Online Comment

Application H23-0062-20
Location CORNER HOUSE CHURCHGATE WHAPLODE PE12 6TA
Proposal Details of scheme to deal with contamination (Condition 7 of H23-0095-19)

Name Sue Armour
Address Environmental Protection Officer SHDC PE11 2XE

Date Submitted 02-04-20
For/Against Comments

TYPICAL RAFT PERIMETER 1:10

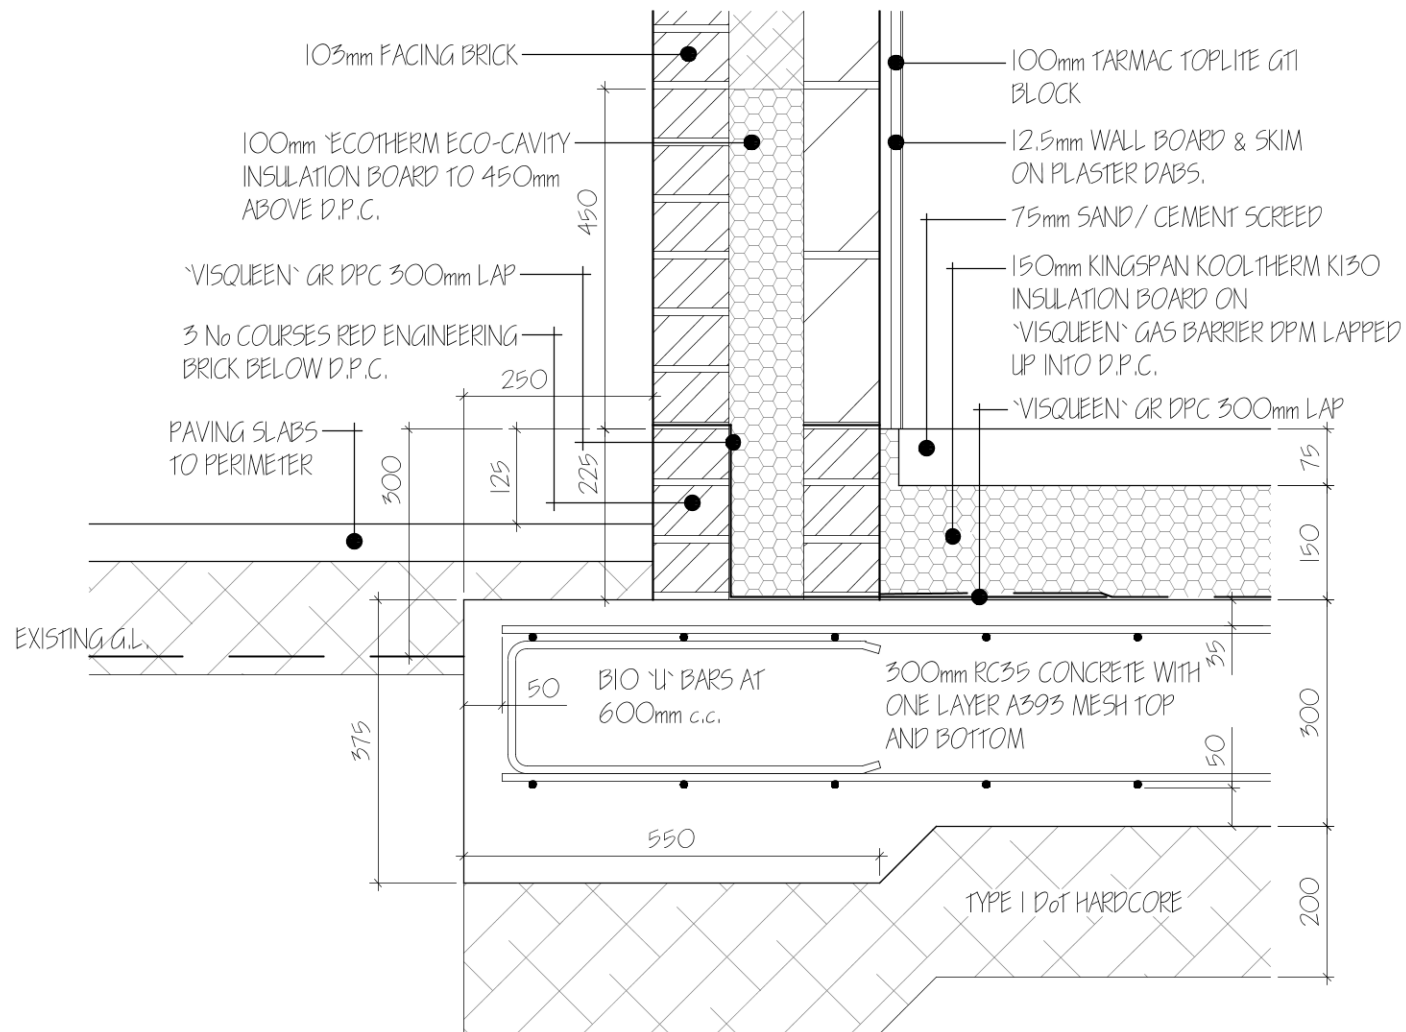
I have reviewed the Humberside Materials Limited Phase 2 (site investigation) report Corner House, Church Gate, Whaplode' ref 0991/4873/P/P2 Rev 0.0 dated March 2020 and the supplied file 'raft perimeter 1-10.pdf'. I am in general agreement with the findings and proposals for ground gas protection measures to be installed. I therefore recommend discharge of parts ii & iii of condition 7 of H23-0095-19, with part iv remaining outstanding until validation is received. This must be before first occupation.

The applicant is advised that we accept first party validation, to include membrane and proprietary component invoices or delivery notes, and photographs of the membrane as it is installed, including any joints etc. Further information can be found in the YALPAG Technical Guidance 'Verification requirements for gas protection systems' which can be downloaded from our website here <https://www.sholland.gov.uk/article/11653/Planning-Application-Consultations-Condition-Discharge>
